KITTITAS COUNTY COMMUNITY DEVELOPMENT SERVICES

October 26, 2022

Subject: Shoreline Exemption Permit (SX-22-00022 Kirk) – Deemed Incomplete – Request for Additional Information

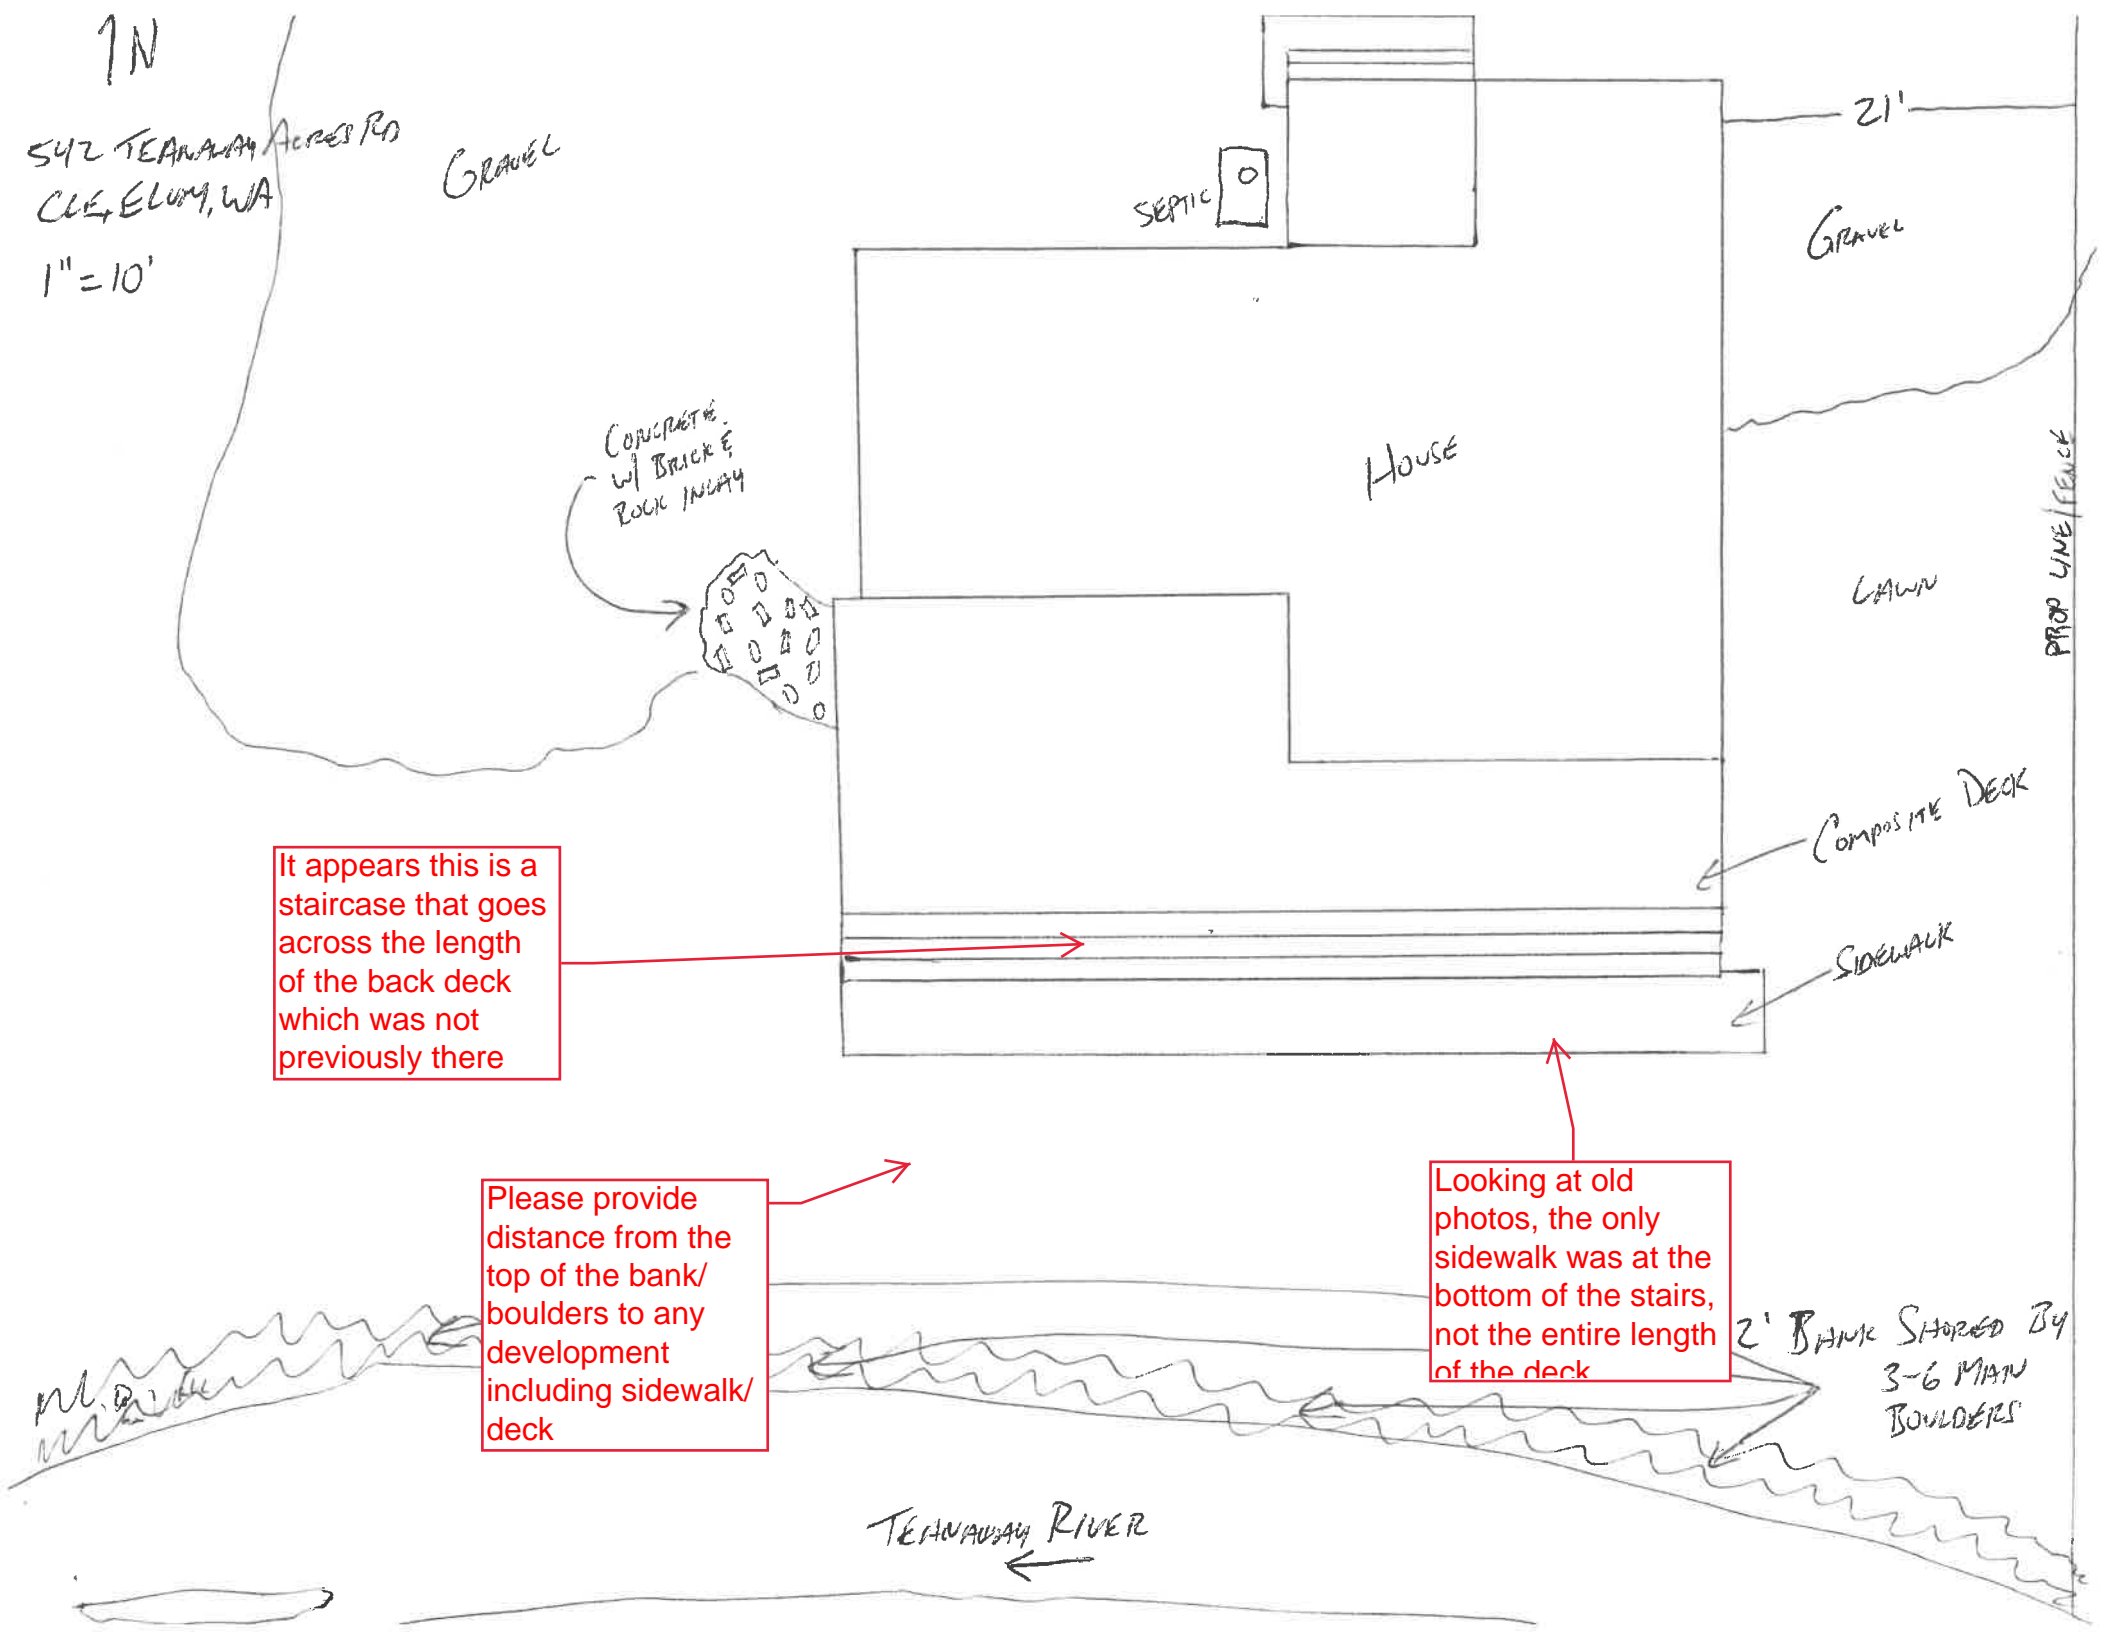
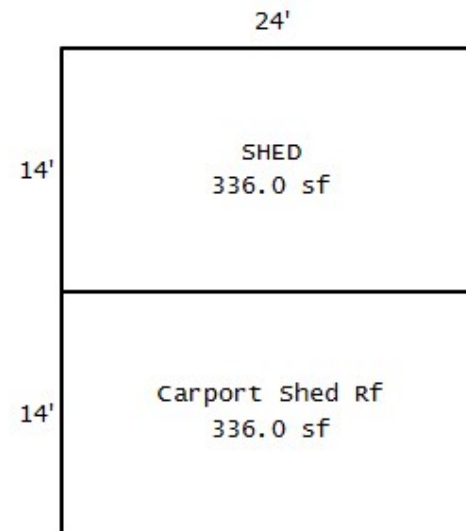
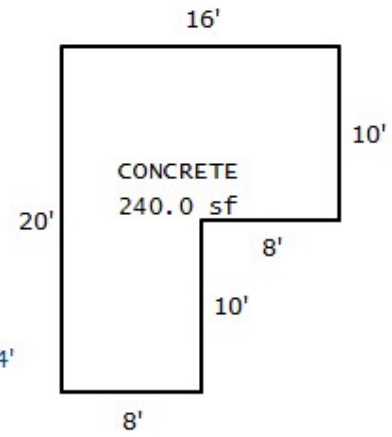
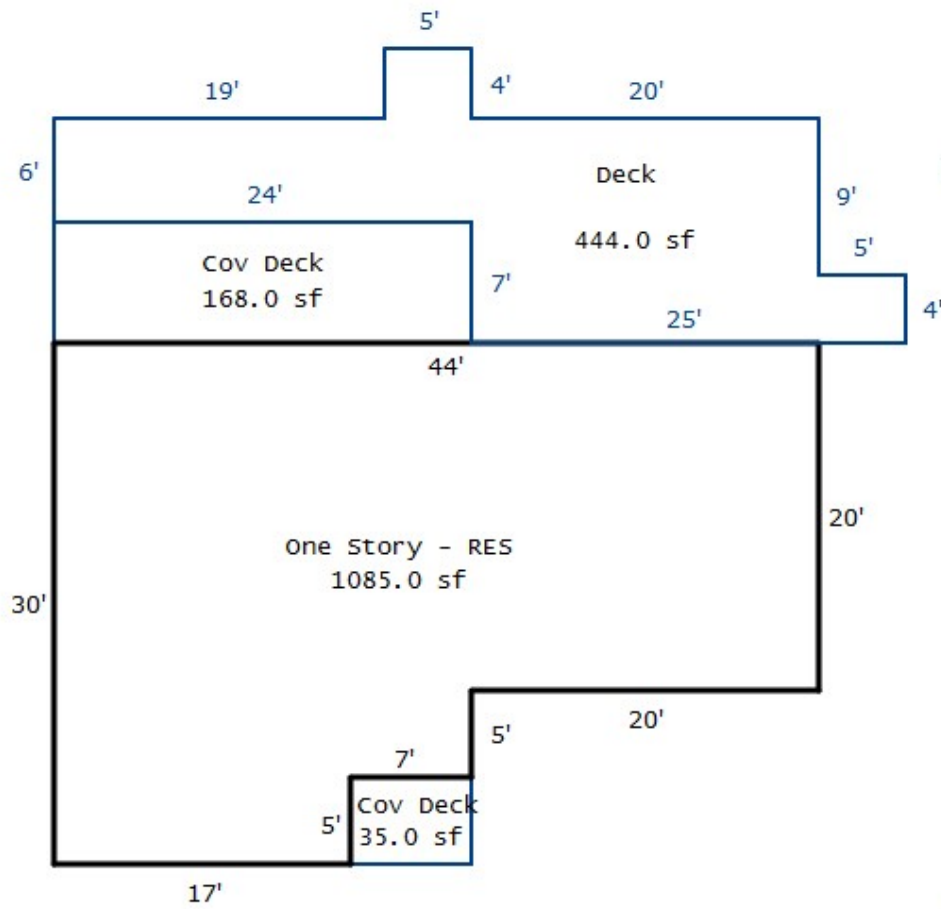
1. Please provide clarification on what appears to be an addition to the legal non-conforming existing structure or an updated correctly scaled site plan. The area of concern has been identified on the attached documents. Any new impervious surfaces and uncovered decks would need to be at least 100 feet away from the ordinary high-water mark (OHWM). The current site plan shows within 20 feet of the OHWM. Please show the distance from the Ordinary High-Water Mark to any structure or impervious surface. No additional covering of the deck can occur than what already previously existed. Staff also did not see any scale on one of the site plans submitted.
